Requested Revisions for 86 Morning Street Permit Application

Attached please find the updated drawings addressing all of your redlines for the renovation of 86 Morning Street. We now plan to demolish the garage, as it is not salvageable.

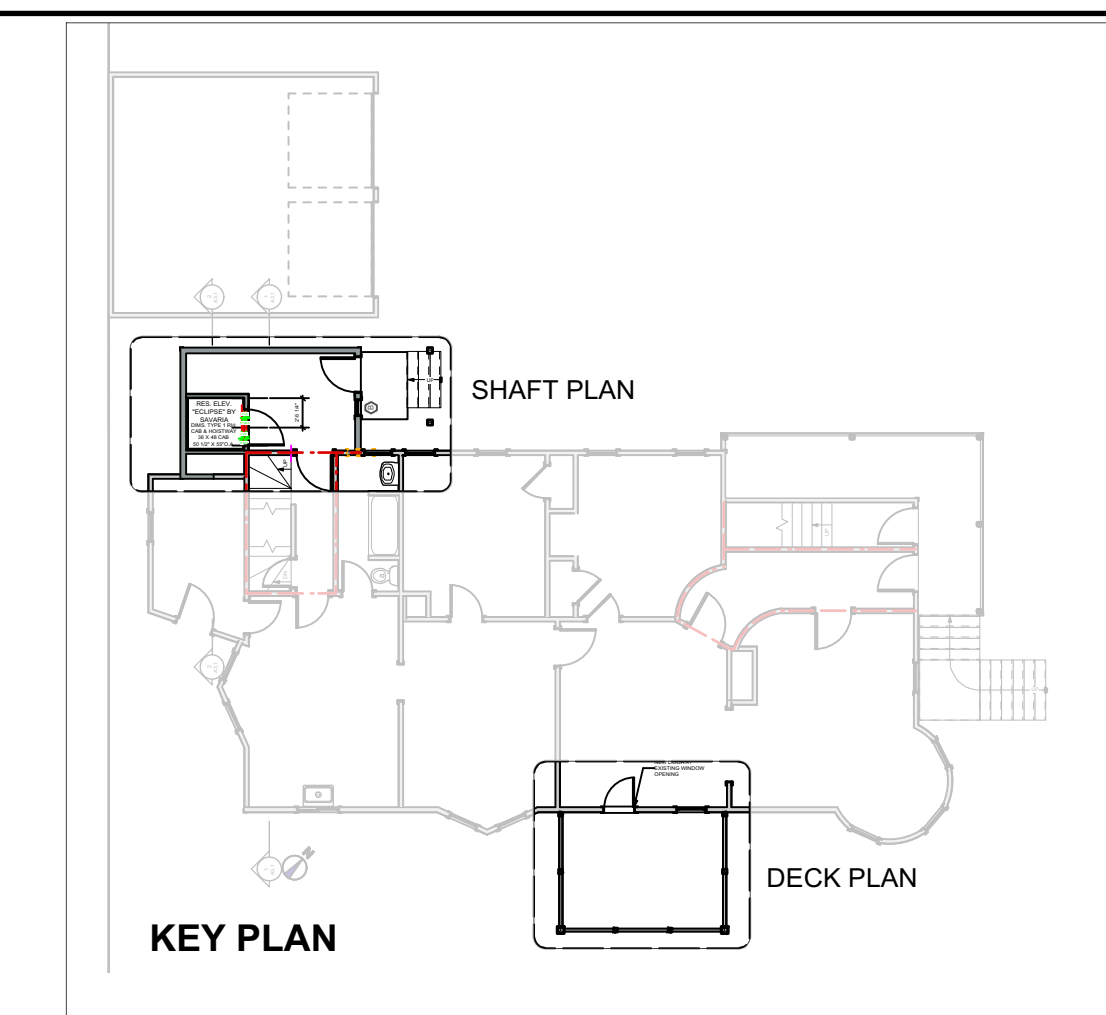
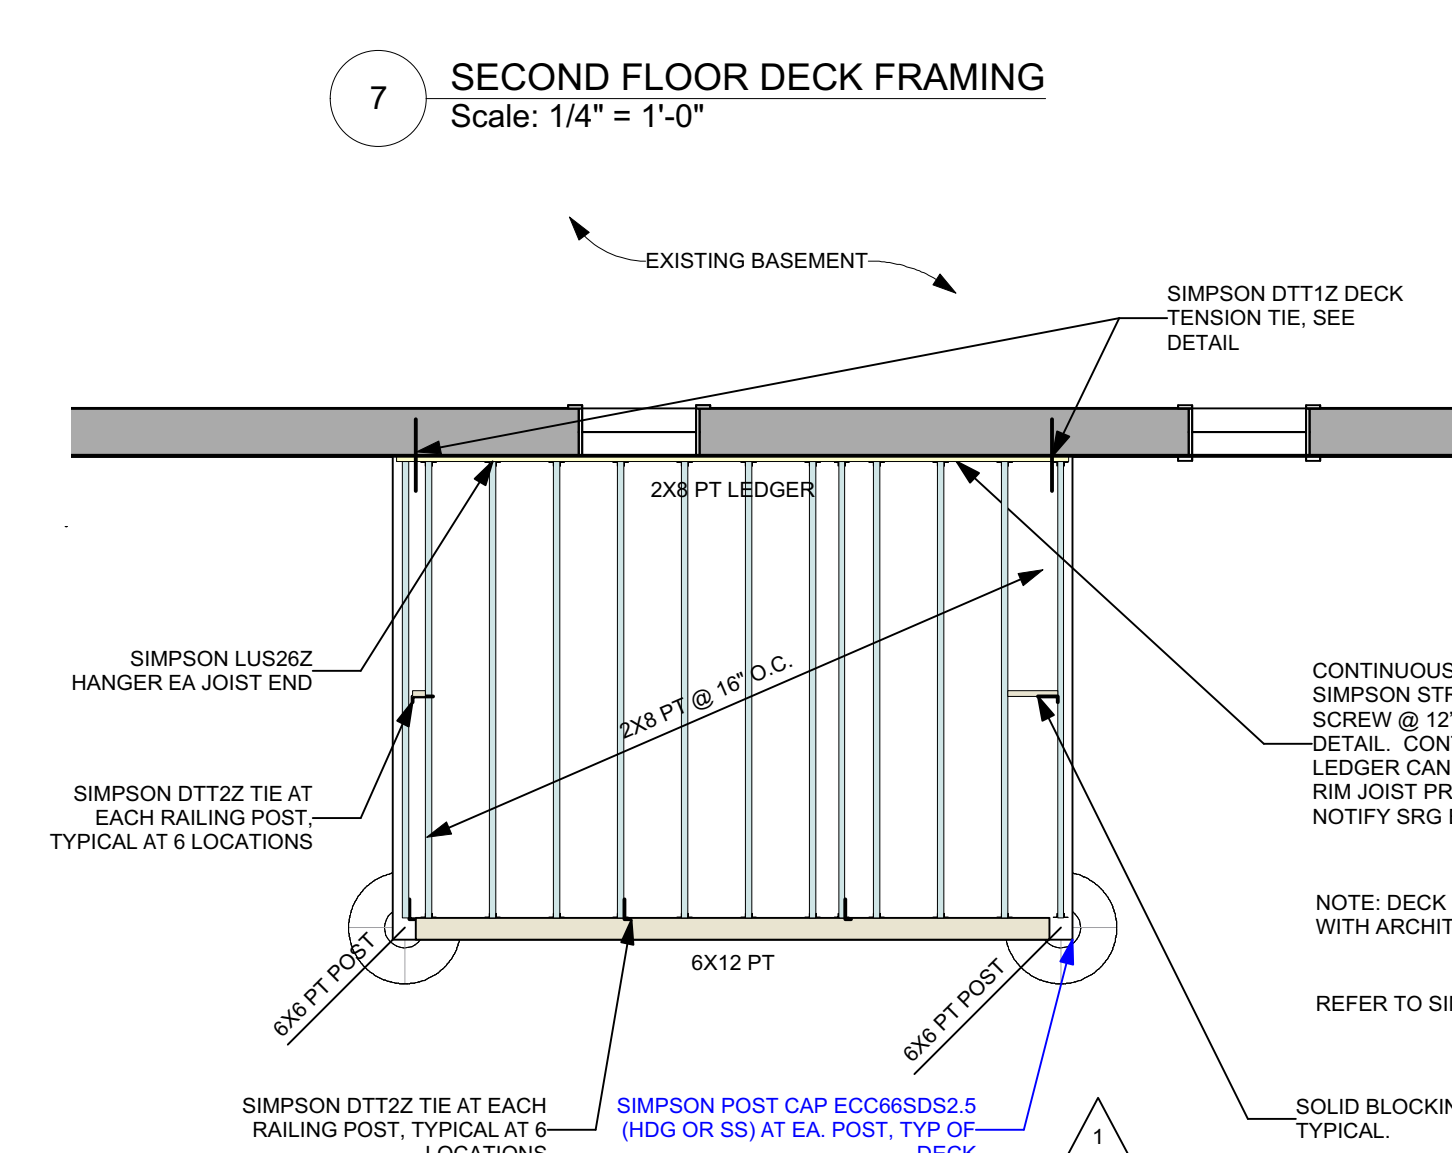
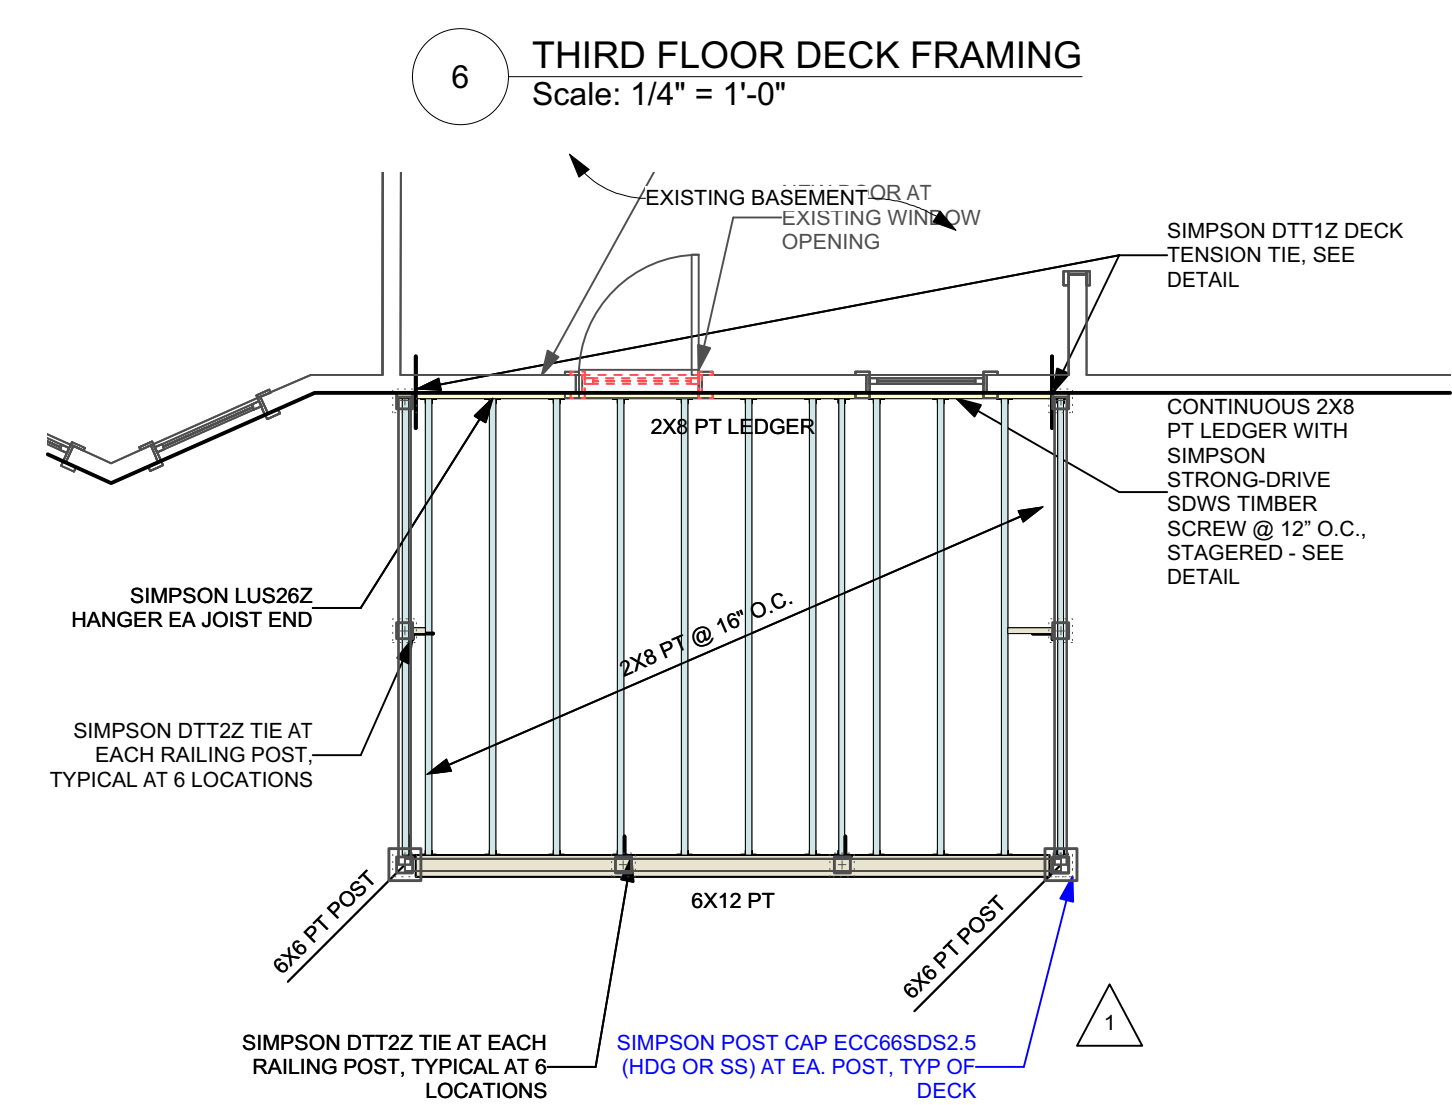
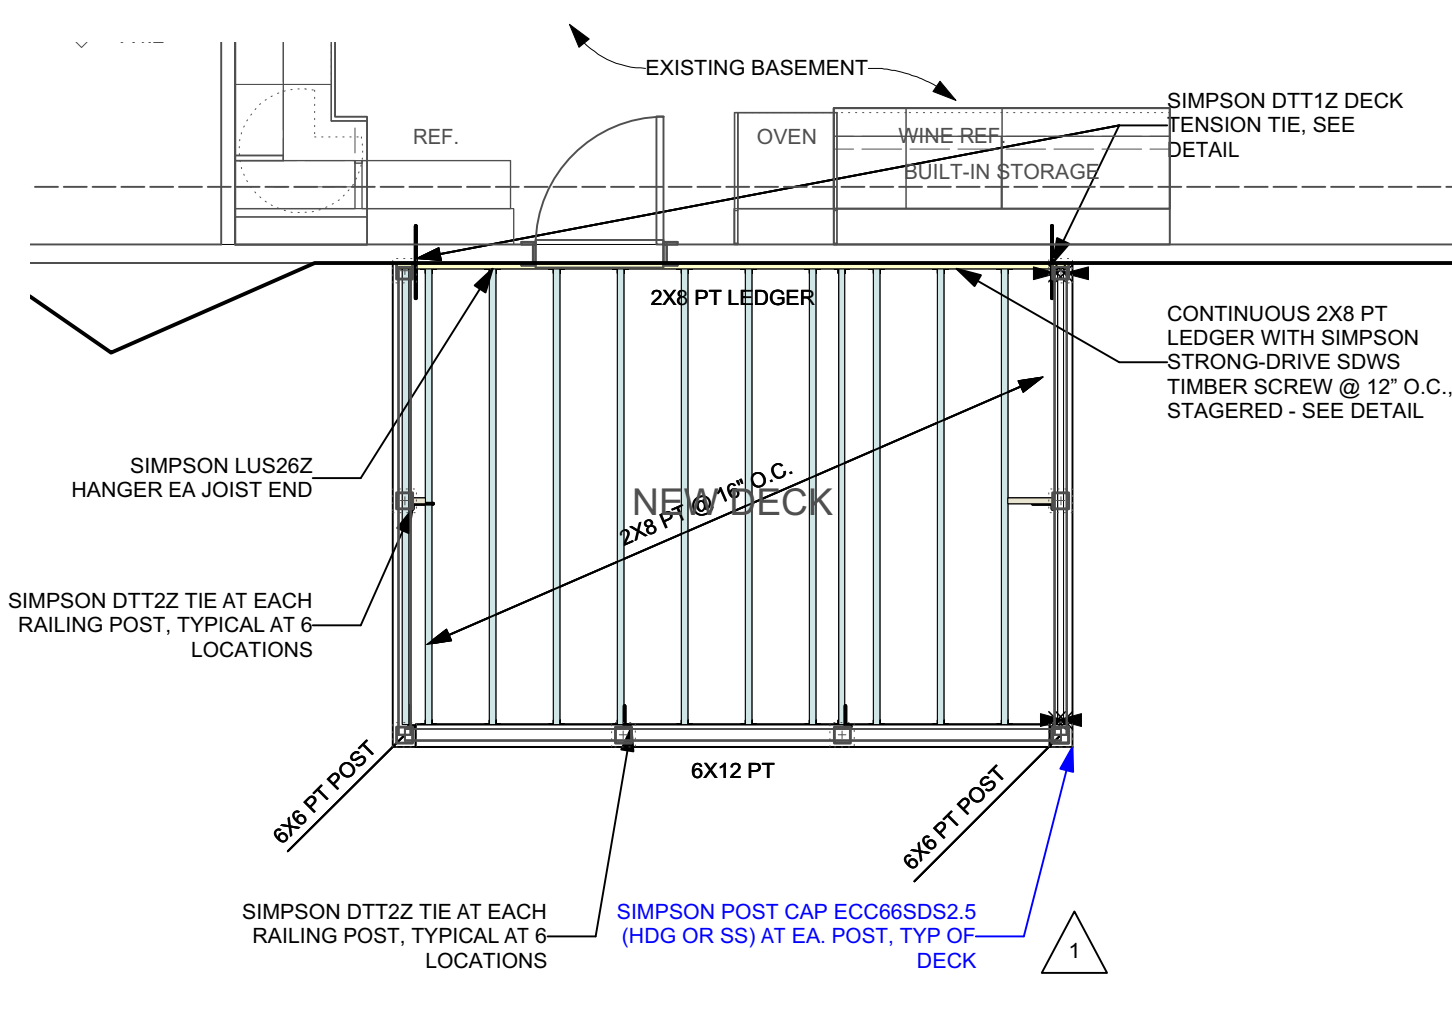
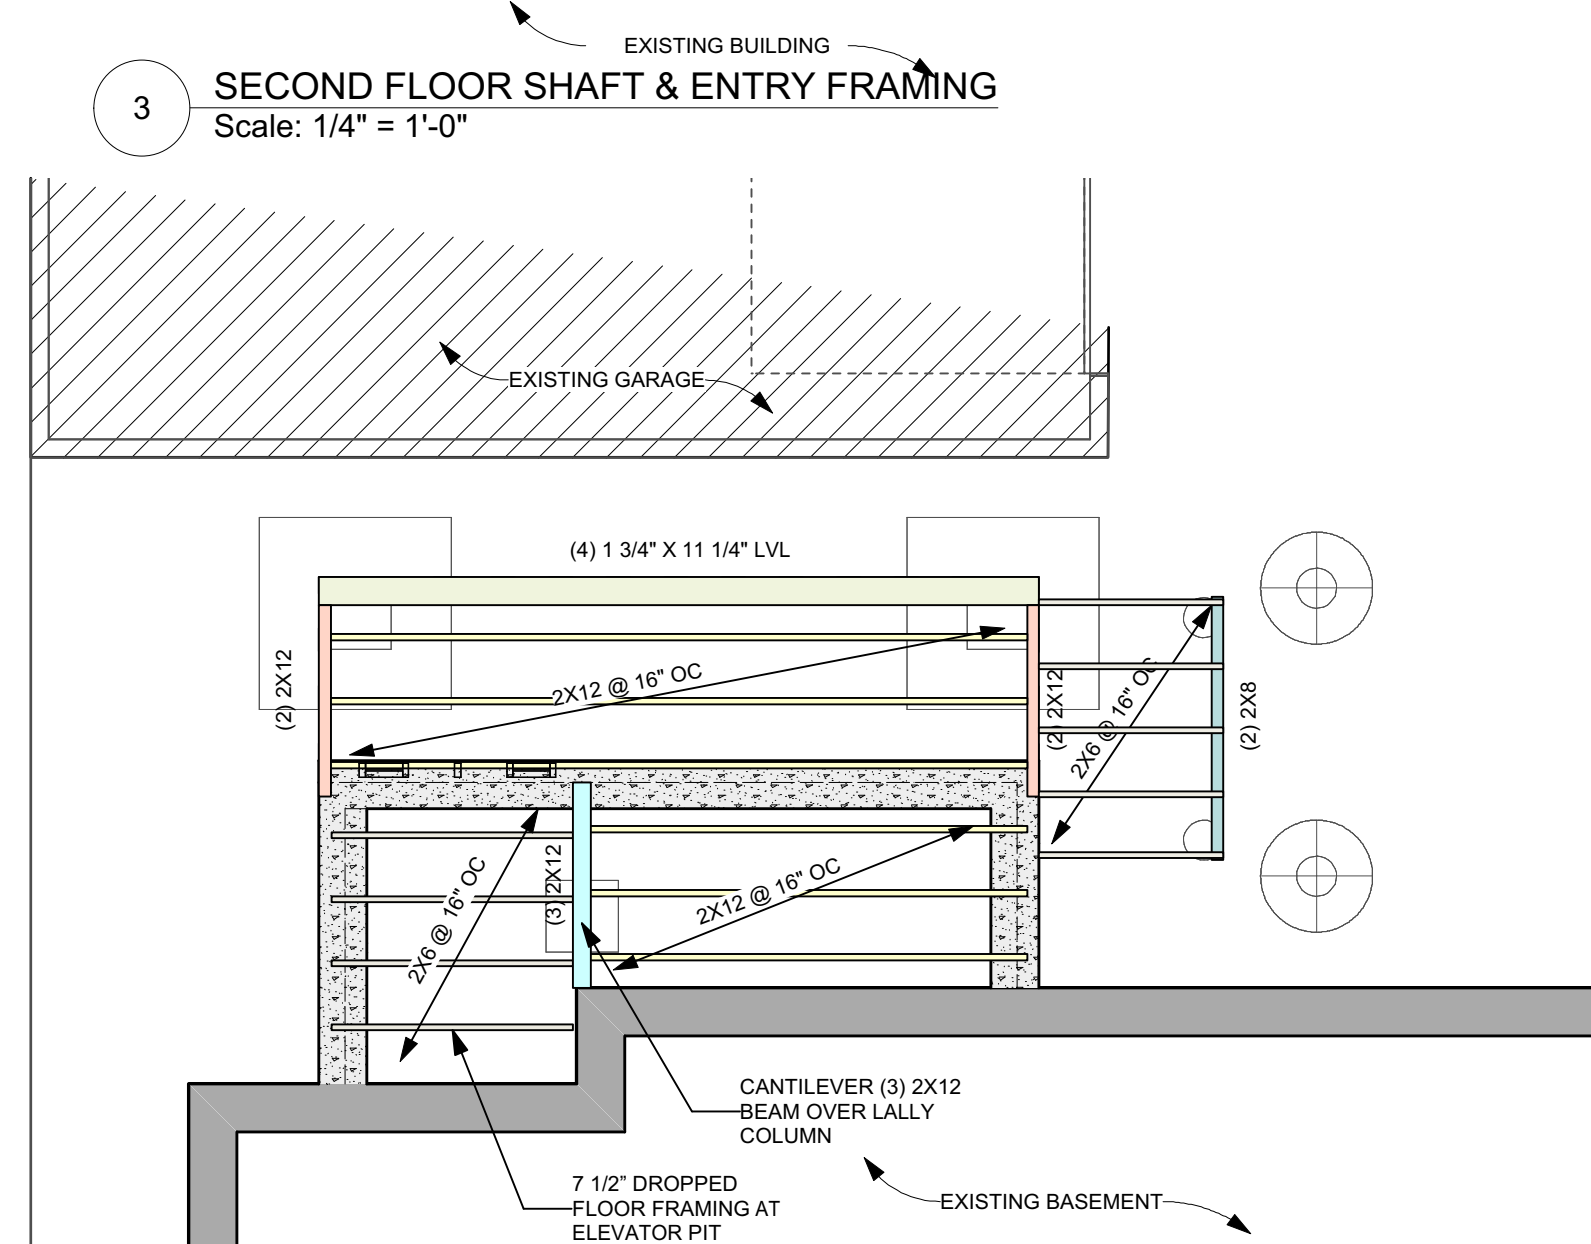
- Post to deck detail added
- Flashing detail at deck to building added
- Added Simpson model number for post caps at deck
- Note explaining that the garage will be demolished under a separate permit, already filed.
